Ribble Valley Borough Council
Council Offices
Church Walk,
Clitheroe
Lancashire
BB7 2RA

Phone: 0300 123 6780
Email: developeras@lancashire.gov.uk
Your ref: 3/2025/0536
Our ref: 3/2025/0536/HDC/KW
Date: 19 September 2025

Location: Dale Hey Bungalow Preston Road Ribchester PR3 3XL
Proposal: Part retrospective outline planning permission to demolish the existing bungalow and proposed new detached self-build 4/5 bedroom house with access applied for (all other matters reserved).
Grid Ref: 364085 436062

Dwmg No. A4578-PL04 Rev. A

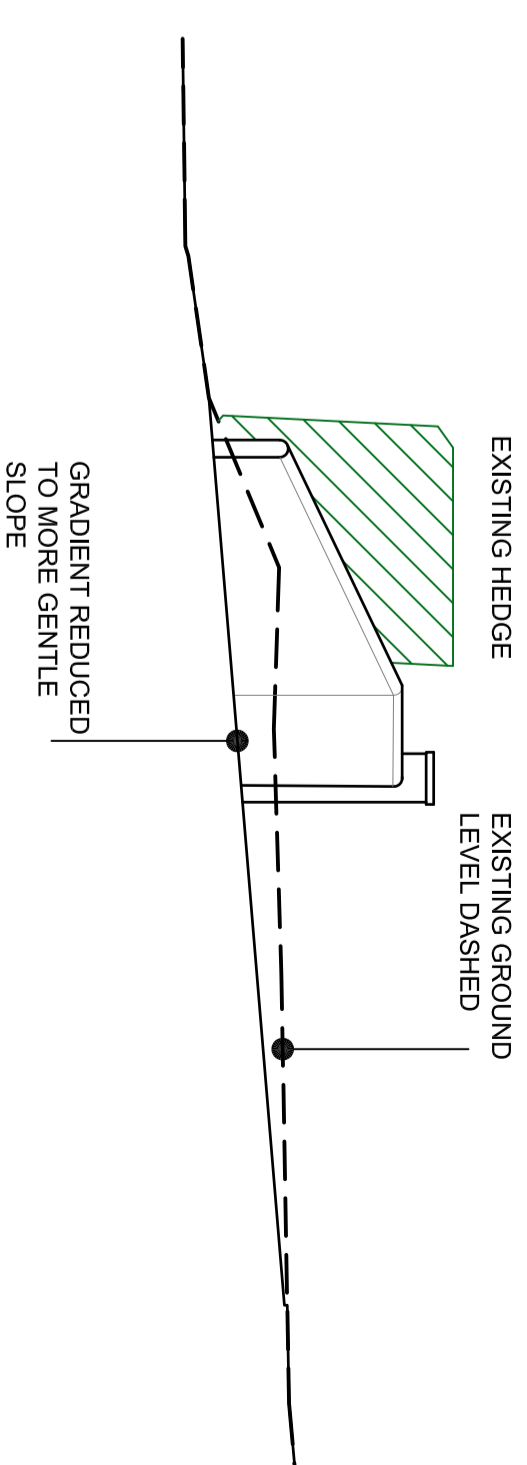
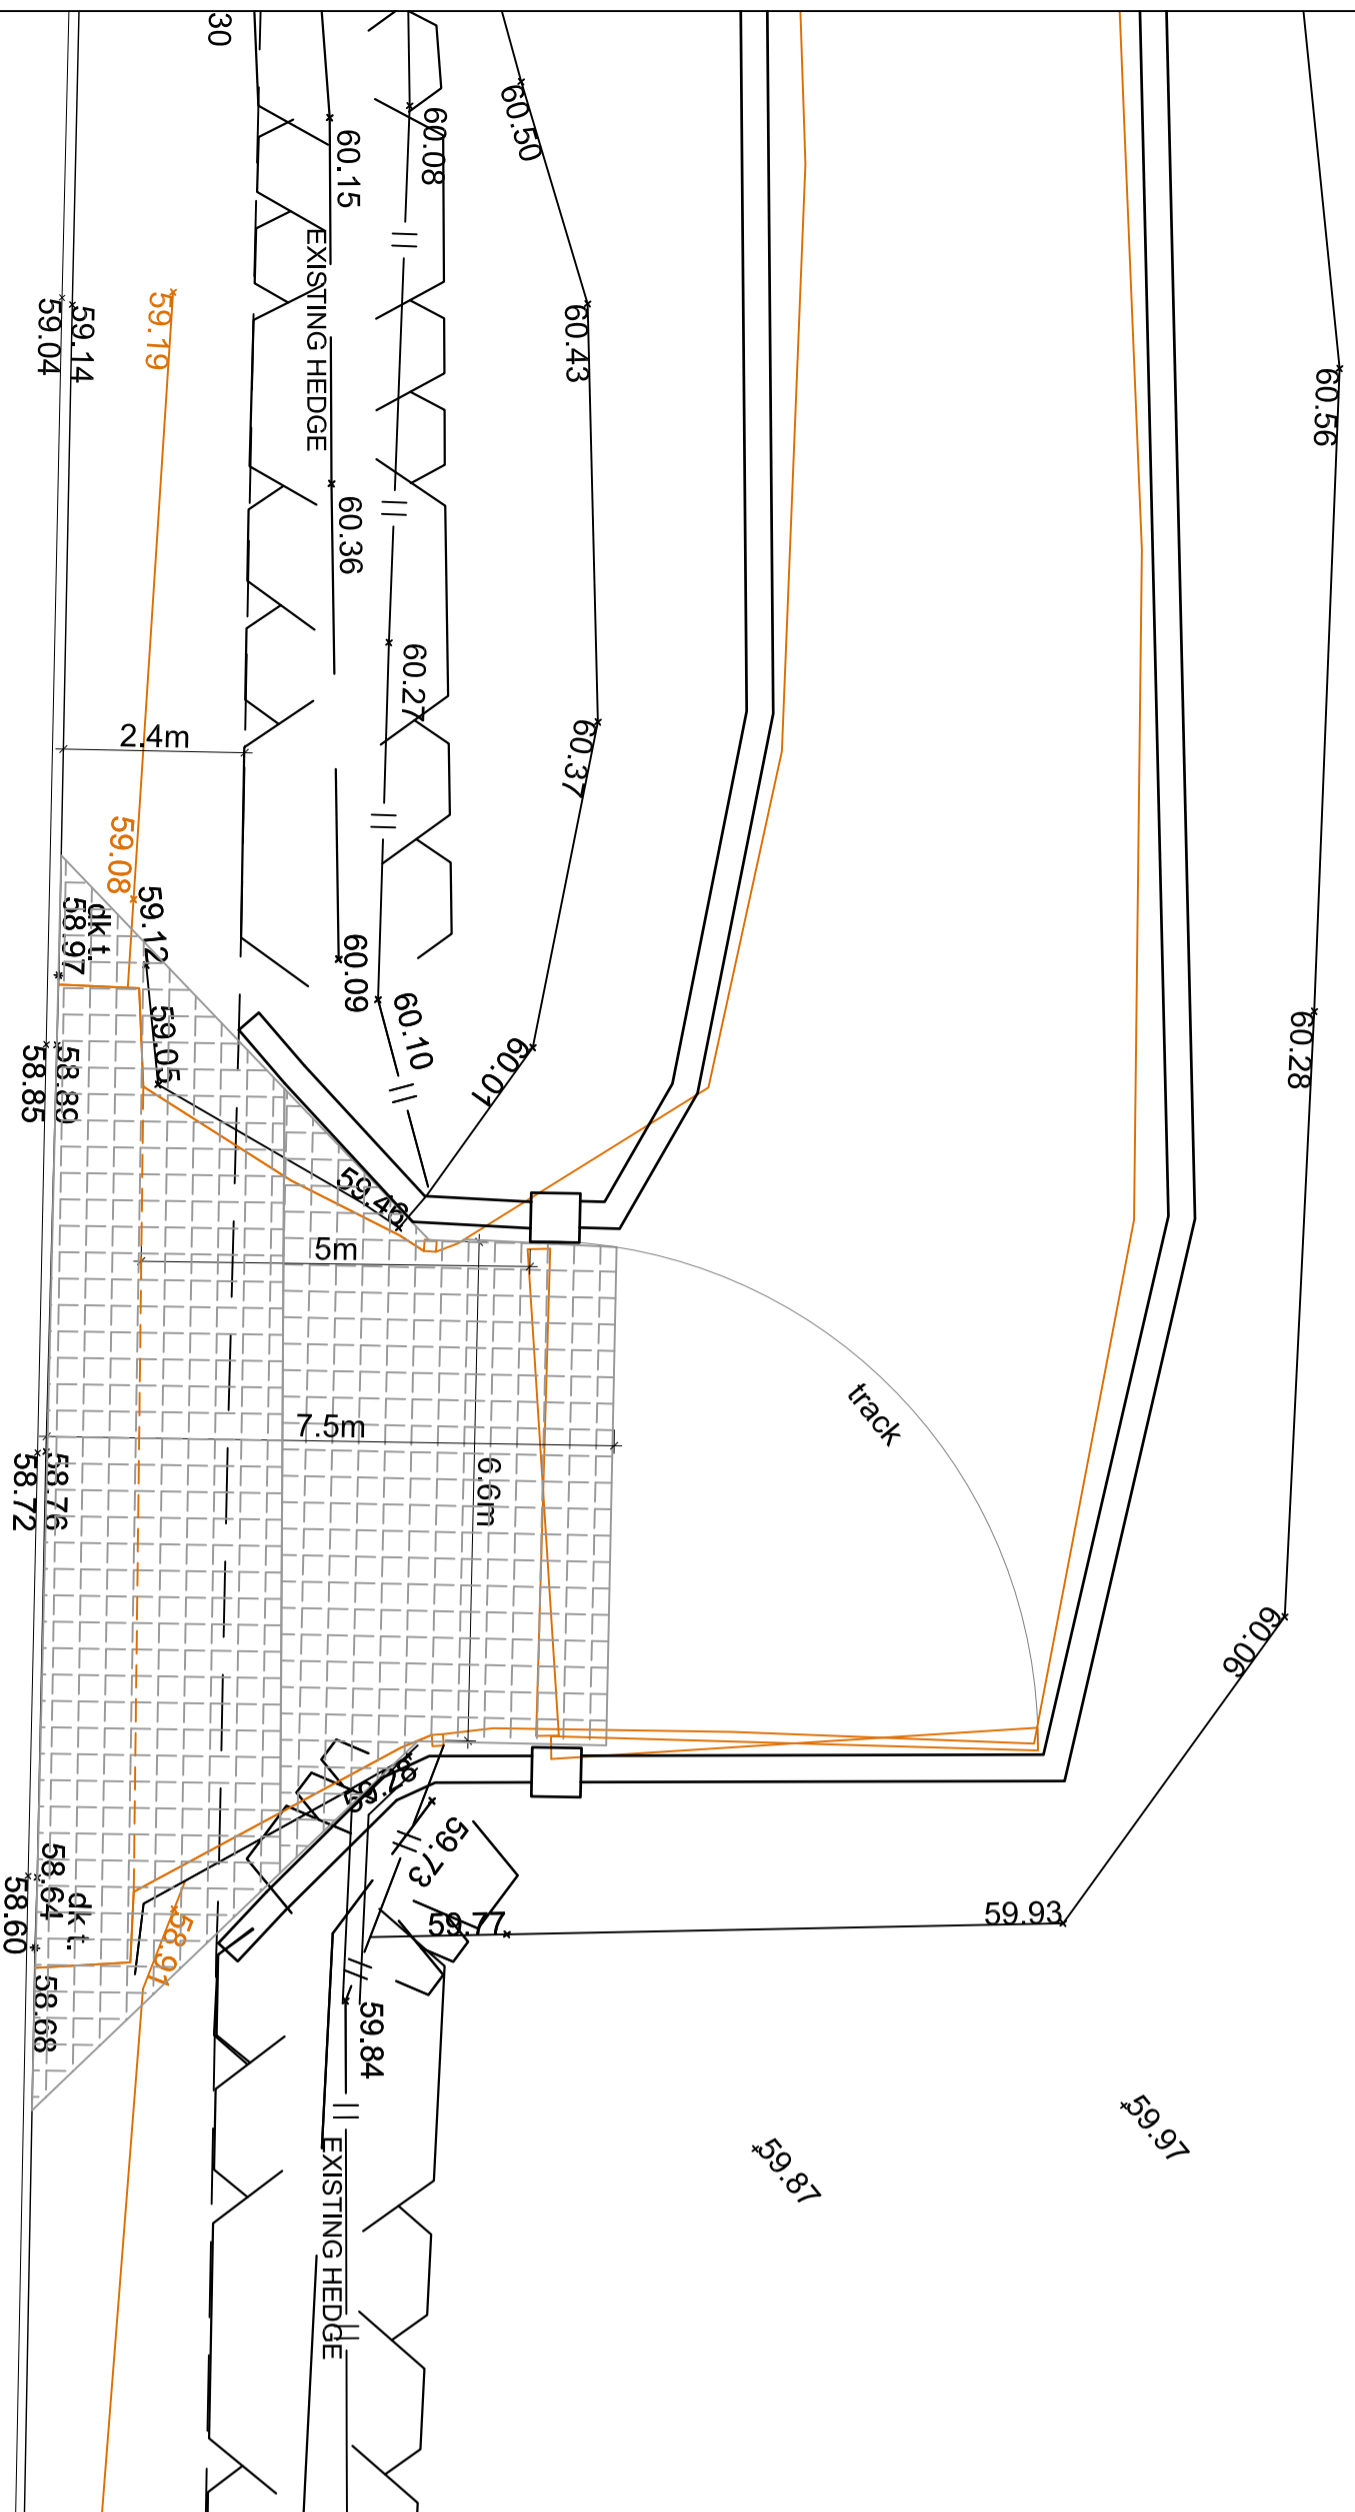
An access layout has been provided as part of this application with the relocation of the access on Preston Road. A new stone wall surrounding the access and gates to the vehicular access is also proposed. All structures and vegetation that fall within the visibility splay, which was approved as part of 3/2017/0813 shall be retained at no higher than 1m.

3. Before the access is used for vehicular purposes, any gateposts erected at the access shall be positioned 5m behind the nearside edge of the footway/carriageway and visibility splay fences or walls shall be erected from the gateposts to the existing highway boundary, such splays shall be 45° to the centre line of the access. The gates shall open away from the highway.
Reason: To permit vehicles to pull clear of the carriageway when entering the site and to assist visibility.
